**Amended Stage 1 State Significant Development Application (SSDA) and Response to Submissions for 201-217 Elizabeth Street, Sydney NSW 2000 (D/2017/349, SSD 8105)**

Thank you for your letter dated 14 November 2017, requesting Transport for NSW (TfNSW) review and comment on the above.

Ground Floor

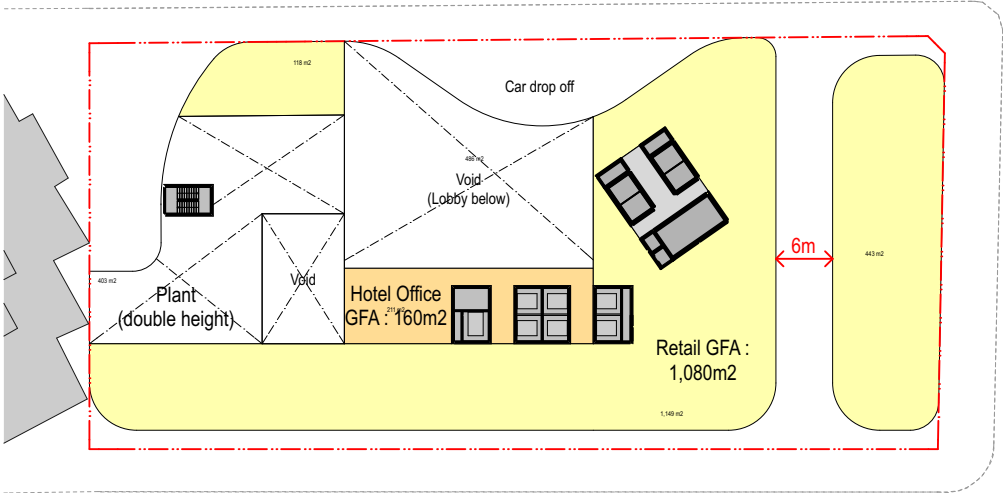
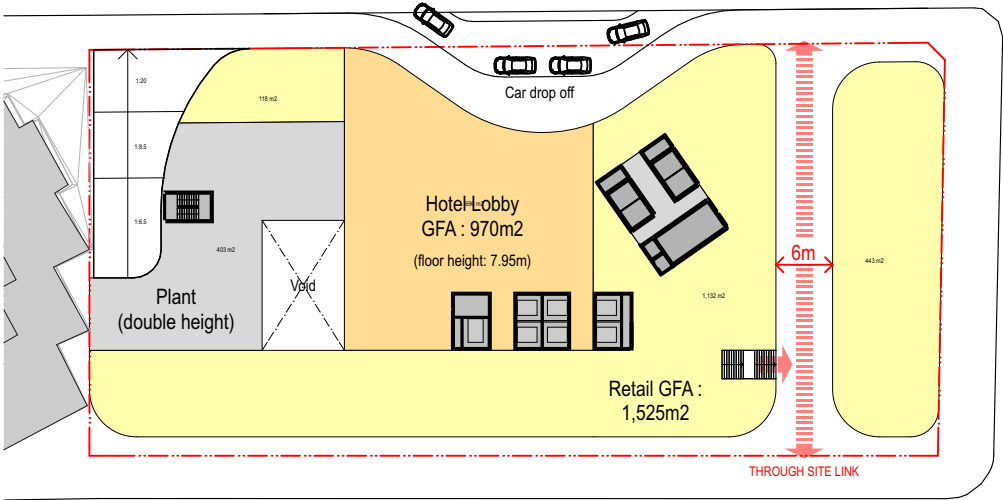
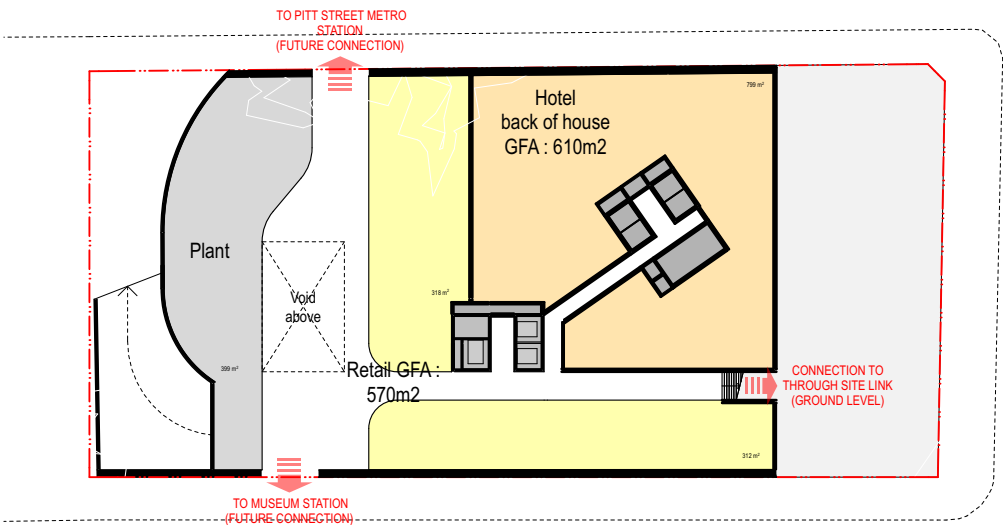
The applicant has revised the proposed hotel pick up/drop off and car park/loading dock arrangement to provide the following:

- Two driveway crossovers along the Castlereagh Street bus stop to provide an at-grade hotel pick up/drop off facility and basement car park/loading dock; and
- A split bus stop arrangement along Castlereagh Street to accommodate the proposed exit driveway for the hotel pick up/drop off facility and car park/loading dock.

The applicant has advised that the proposed split bus stop arrangement would continue to operate in a similar way to existing conditions.

TfNSW advises that the proposed split bus stop arrangement would substantially restrict the operation of bus services at the subject bus stop and consequently TfNSW does not support the proposed split bus stop arrangement. TfNSW advises that the applicant should amend the design of the proposed hotel pick up/drop off and car park/loading dock arrangement to retain the existing conditions of the bus stop.

TfNSW advises that it does not support any changes that will have an adverse impact on the bus stops on Castlereagh Street. Therefore, TfNSW requests that the applicant be conditioned to consult with the City of Sydney and the Sydney Coordination Office to investigate a hotel pick up/drop off and car park/loading dock arrangement which minimises impacts to bus operations, general traffic, cyclists and pedestrians, prior to design competition or any Stage 2 Development Application lodgment for the subject site.

TfNSW recommends that the applicant be conditioned to prepare a car park and loading dock management plan to include the following (not limited to):

- Swept paths of vehicles entering and exiting the hotel pick up/drop off facility and car park/loading dock;
- Management of queuing along Castlereagh Street as a result of the proposed hotel pick up/drop off facility and car park/loading dock arrangement;
- The details of alternate car parking locations and loading zones to redirect vehicles due to extensive queuing at the access to car park;
- Management of incidents at the access to the hotel pick up/drop off facility and car park/loading dock;
- Loading dock management details including service vehicle movements during peak periods;
- Management of conflicts between cars accessing the car park and vehicle movements to/from the loading dock; and
- Management of conflicts between vehicles accessing the site and pedestrian movements along Castlereagh Street.
